REQUEST

Current Zoning: N1-A (neighborhood 1-A)
Proposed Zoning: UR-2(CD) (urban residential, conditional)

The petition proposes to allow a 14-unit townhome development on a vacant parcel located between Park Road and Wintercrest Lane and on the north side of Fairview Road.

**REZONING**  
**SITE PLAN**  
 PETITION #:  
 2023-037

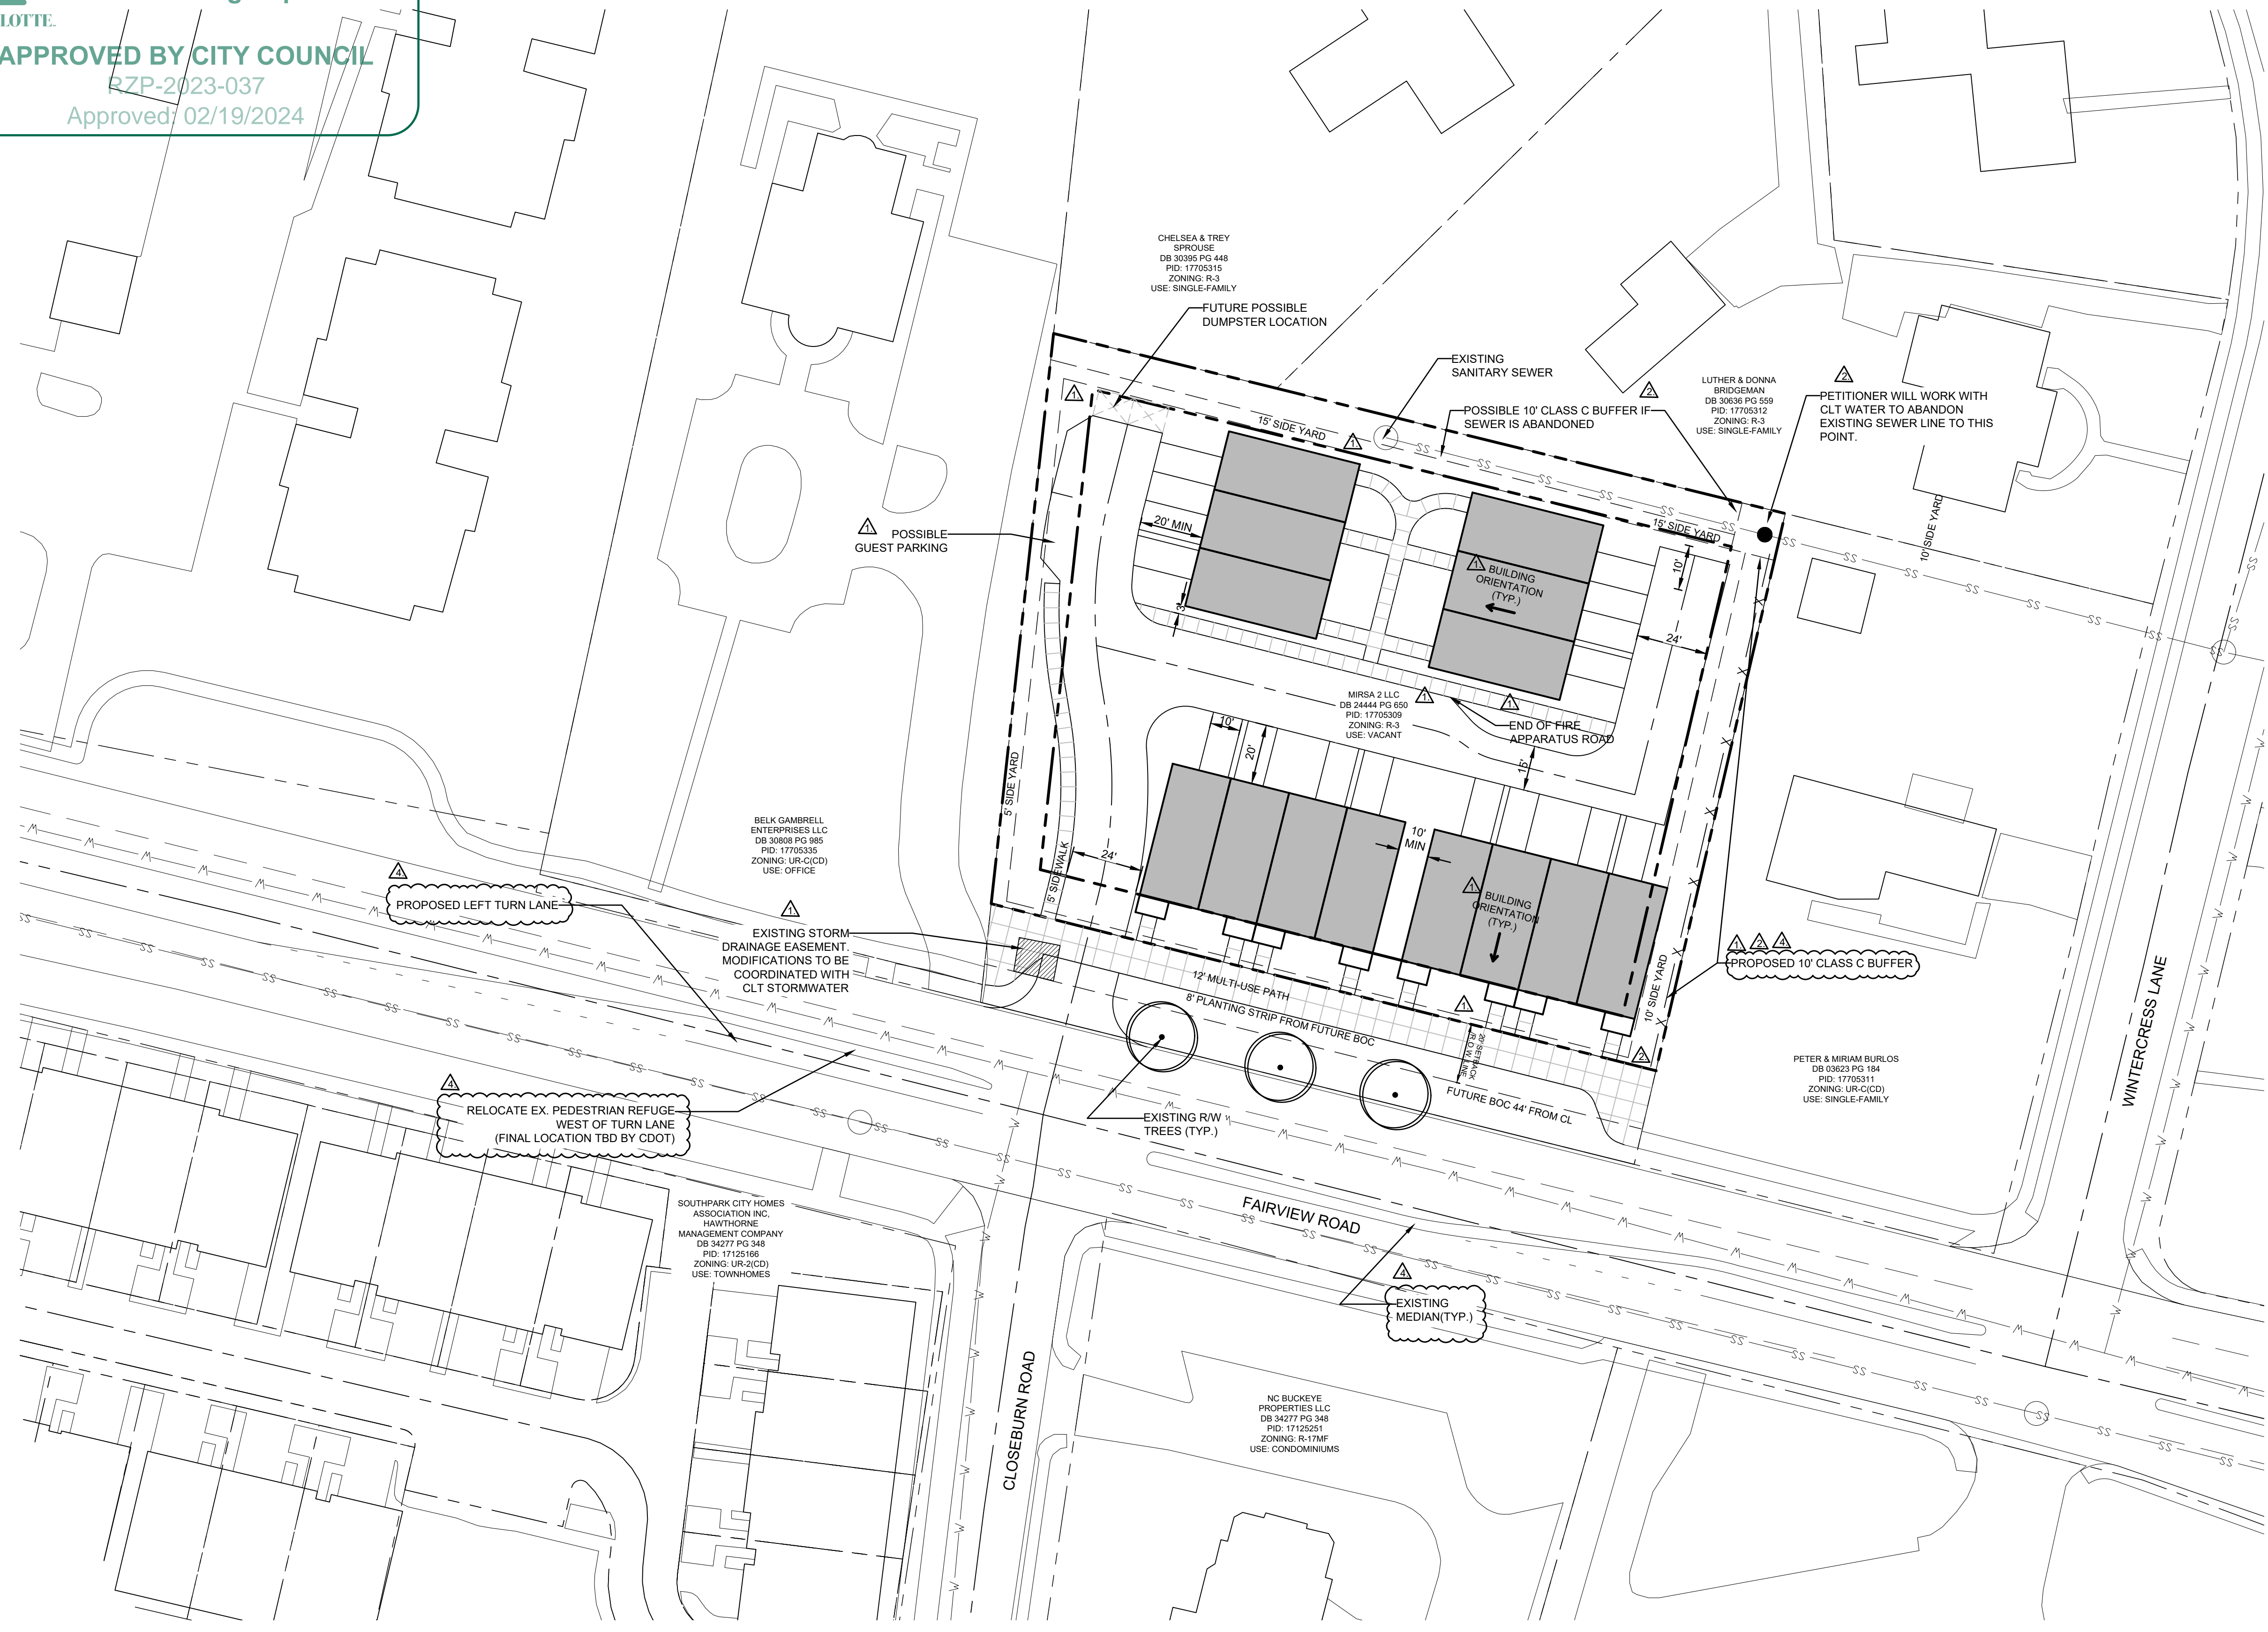
1. ~~Limit the building height to 45 feet.~~ **Addressed**
2. ~~Proposed eight-foot Class C buffer along east property line should be increased to 10 feet with language included it will not be reduced by 25%. Update: There is a discrepancy between labeling on the site plan and Note V.2. Please revise so note matches the graphic depiction of a 10' wide buffer.~~ **Addressed**

4. ~~Amend language to Limit the number of dwelling units in one building to four when fronting Fairview Road.~~ **Addressed**
5. ~~The site plan shows a 15-foot sanitary sewer main line that runs parallel to a portion of the north property line. The petitioner needs to show and label the actual width of the sanitary sewer easement on the site plan. Provide a minimum 10-foot Class C buffer outside the sanitary sewer easement along the north property line. Show and label the buffer on the site plan and commit to this improvement in the development notes, specifying to not be reduced by 25%.~~ **Rescind Petitioner's response: We are unable to make this commitment due to space limitations on site. We can commit to providing a buffer if the sanitary sewer easement is abandoned.**

- Notes garage doors will not front Fairview Road.
- Proposes a minimum ~~eight~~ **ten (10)** foot-wide Class C buffer, ~~planted to 10-foot wide standards~~ along the east property line, to not be reduced by 25%.

- Notes petitioner shall work with Charlotte Water to partially abandon the existing 15-foot sanitary sewer main line parallel to the Site's northern property line and replace with a minimum 10-foot wide Class C buffer, to not be reduced by 25%.
